MEMORANDUM

FROM: Charlene Durham, Engineering **CCES Responses**
719-520-7951
Jeff Rice, Engineering
719-520-7877

SUBJECT: SF-22-041 – Retreat at TimberRidge Filing No. 3
Fifth Submittal

RETREAT AT TIMBERRIDGE
FLING NO. 3
JOB NO. 1185.30
DECEMBER 8, 2022
SHEET 2 OF 5

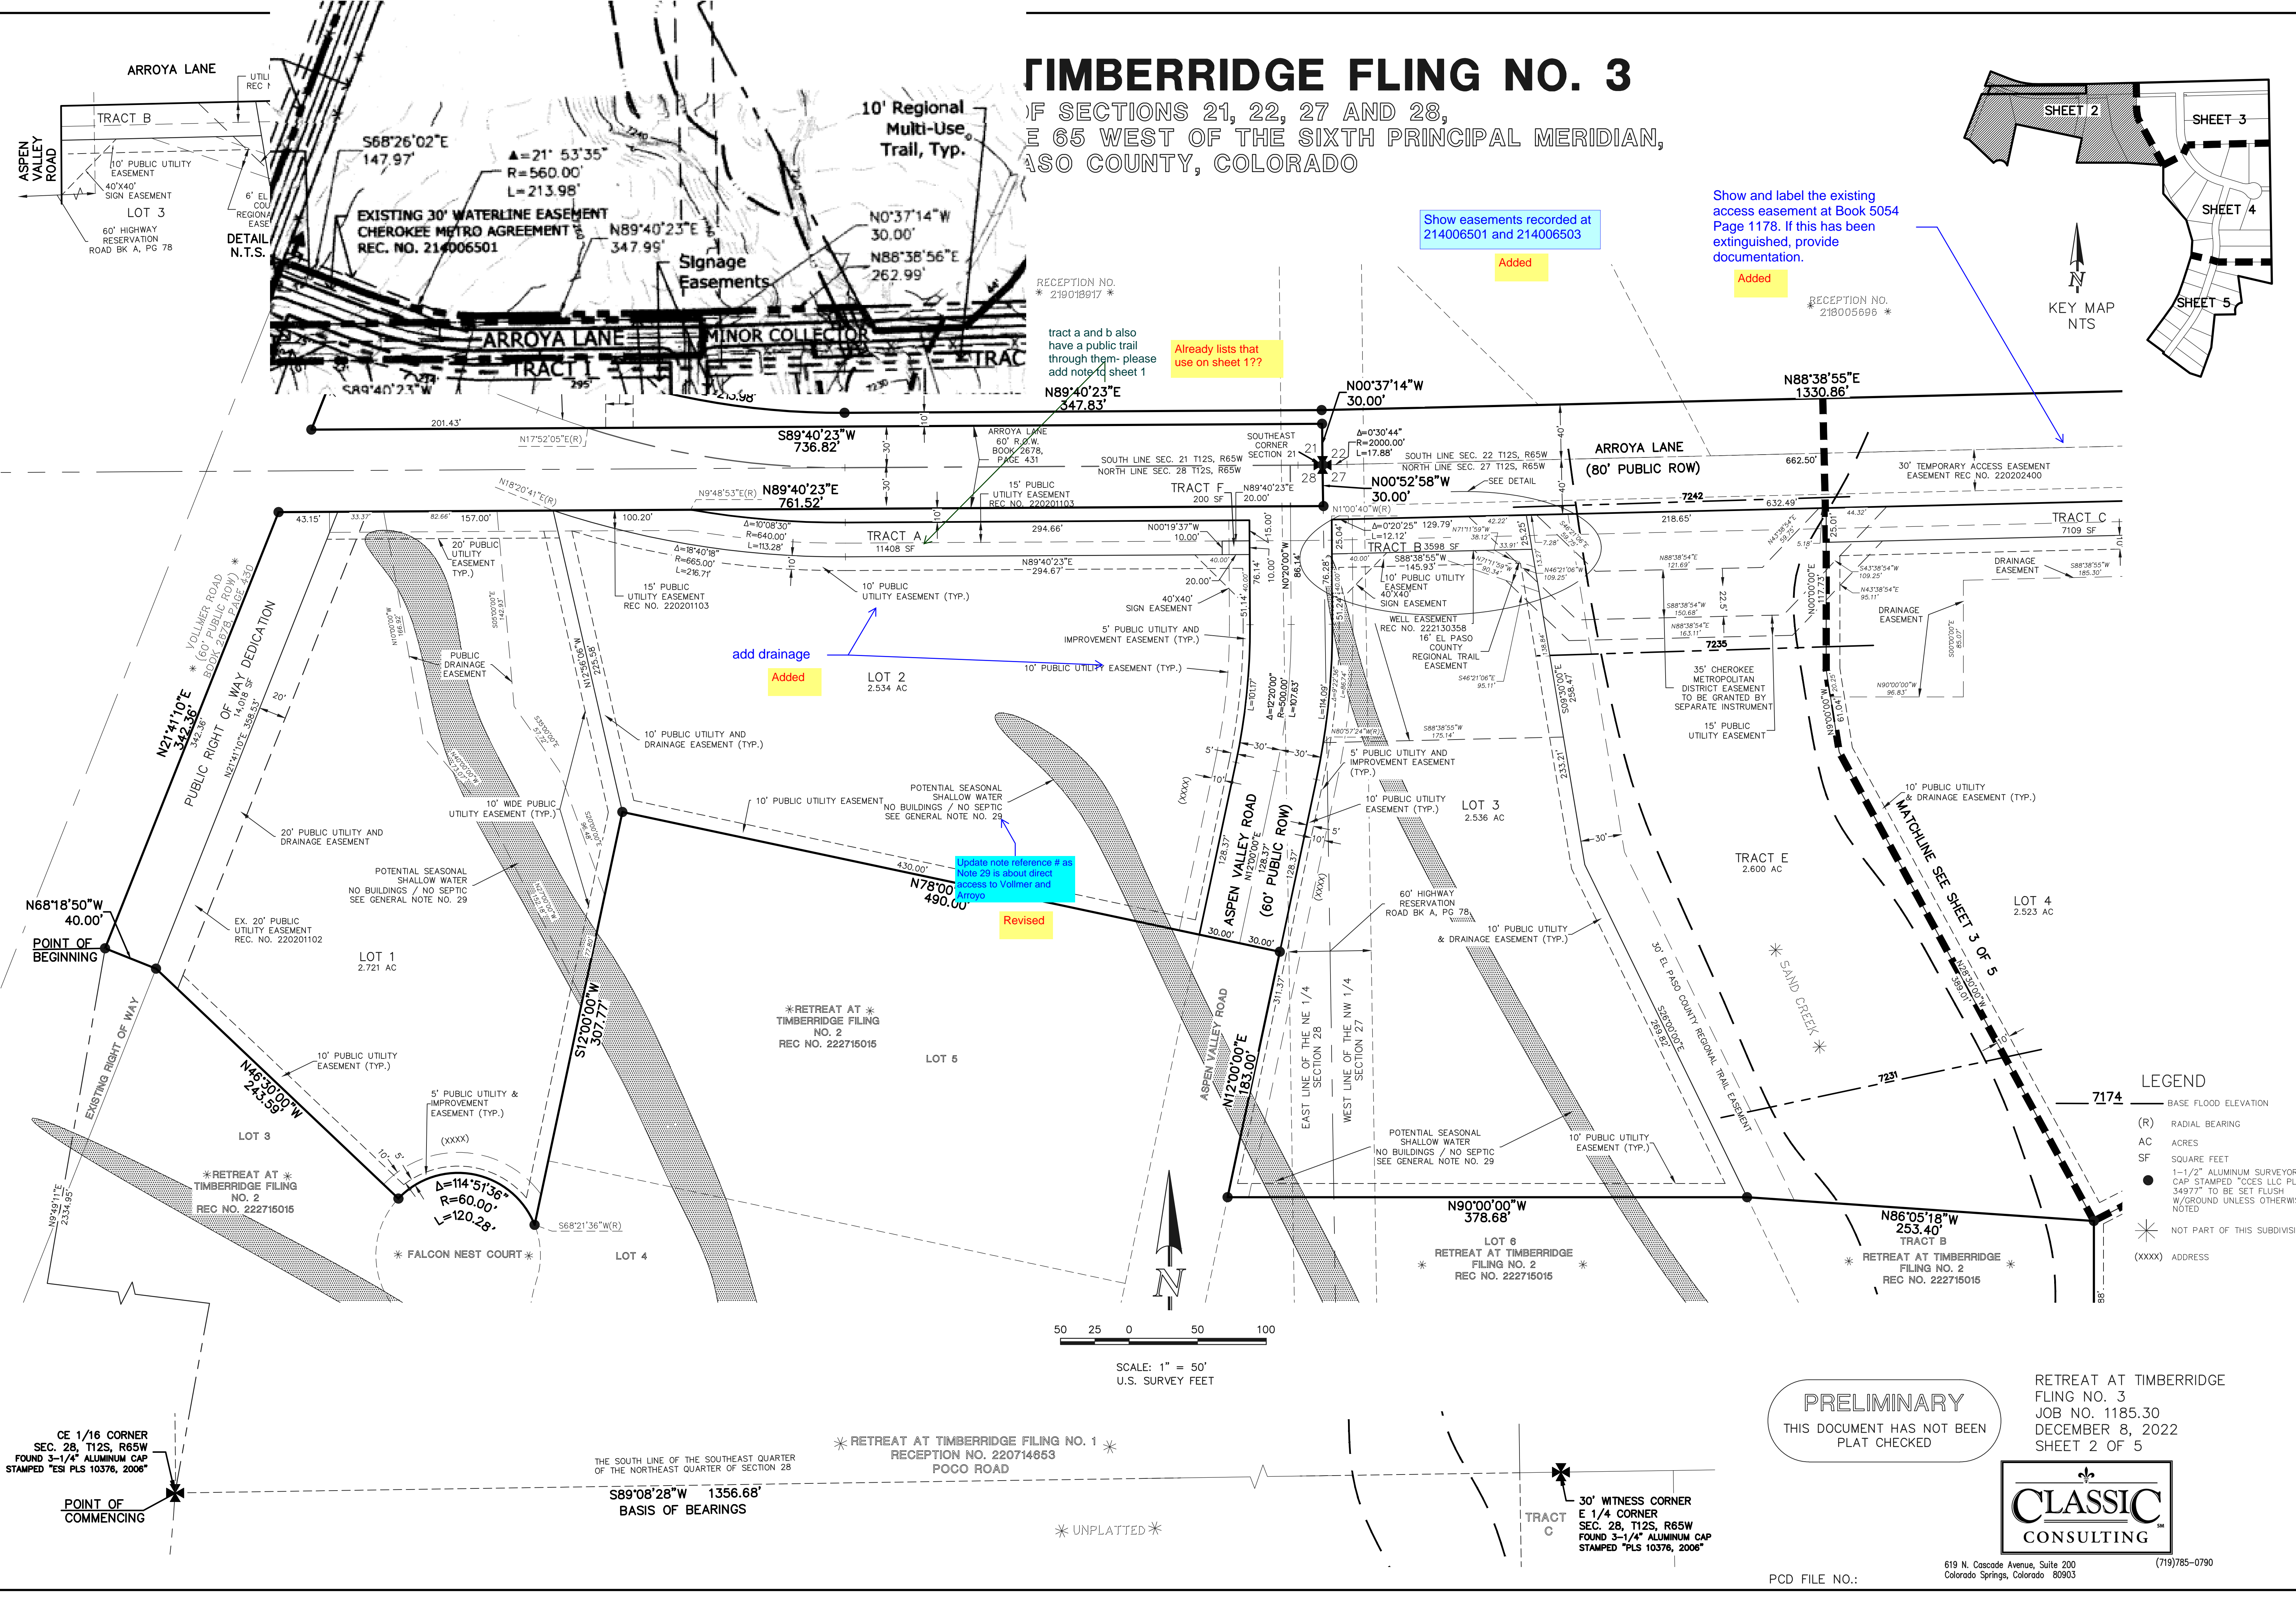
1. *Resolved.*
2. Show and label the existing access easement from Arroya Lane recorded at Book 5054 Page 1178. If this has been extinguished, provide documentation; if not, address how this will be addressed to allow the County to take ownership of the ROW. All existing access and utility easements within the proposed Arroya Lane right-of-way shall be terminated or subordinated as appropriate so as not to encumber the proposed right-of-way prior to County acceptance of the Arroya Lane improvements. This also applies to the easement recorded at 220174515 within proposed Hawks Hill Court. **Partially resolved. The portion of the above comment regarding access easement recorded at Book 5054 Page 1178 still needs to be addressed (as discussed). Classic attorney working with County attorney to resolve.**
